Your Ref: OWPC1378
Our Ref: AB/105/13/L 24-09-2013
Please ask for:
Mr P Cleveland

14th November 2013

Application for Listed Building Consent for redevelopment and conversion of the former Bevin Bevin site to provide 7No. apartments and 6No. houses with associated car parking
Bevin Bevin & Co Ltd River Road Arundel

Drawing **Houses 10 & 11** Scale:@A3 **1:100**

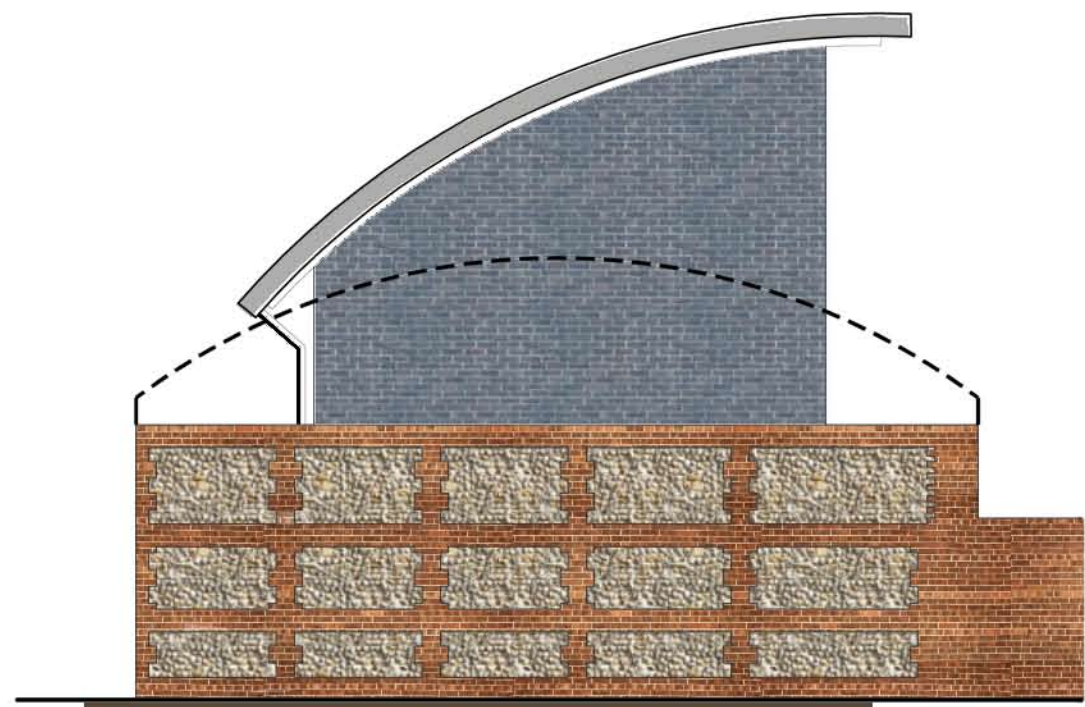
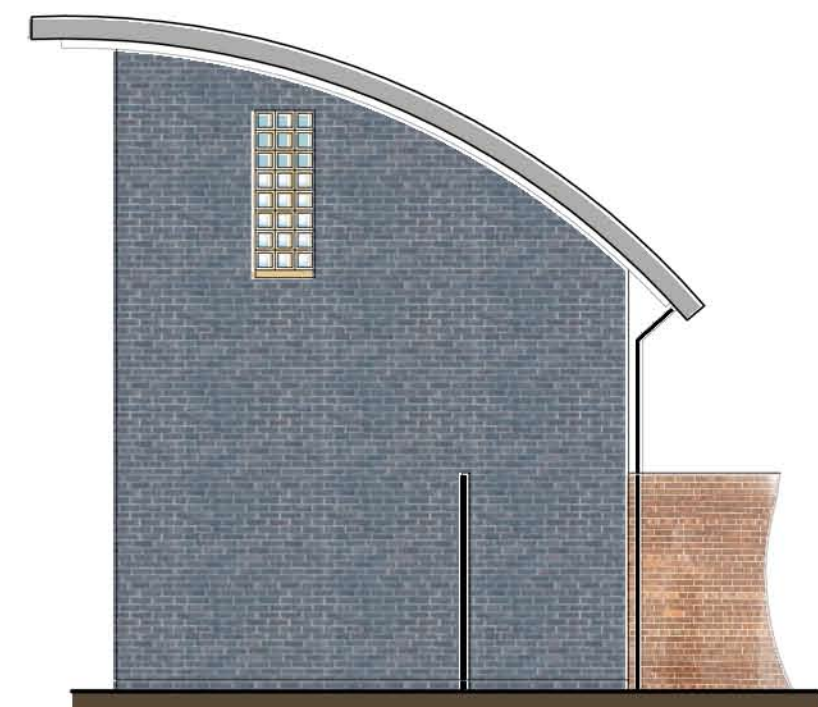
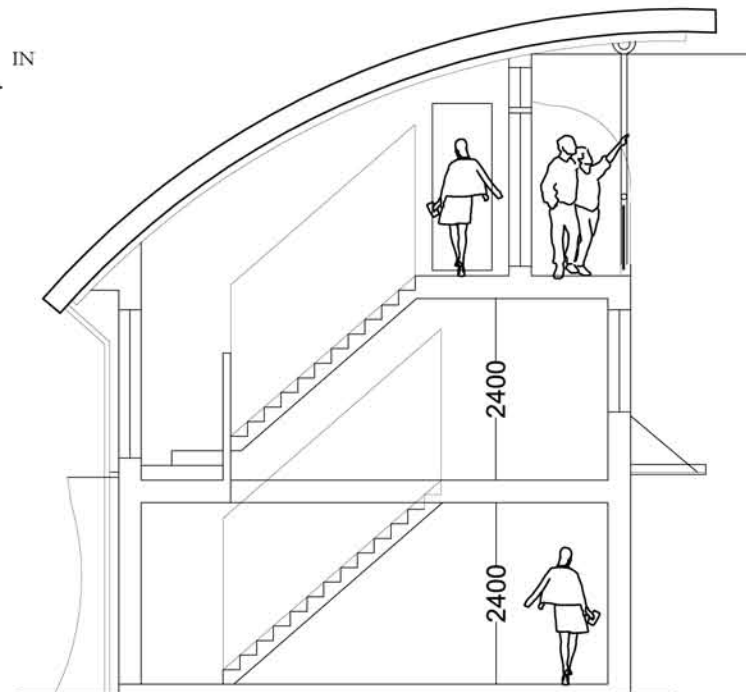
It is unclear if the east facing balconies on proposed houses 10, 11 will directly overlook the rear garden of 24 River road. If current elevation of buildings is maintained it is very unlikely that this issue will be a problem. Only objection is if these east facing balcony is sufficiently elevated to cause direct overlook. Otherwise 'no objection'.
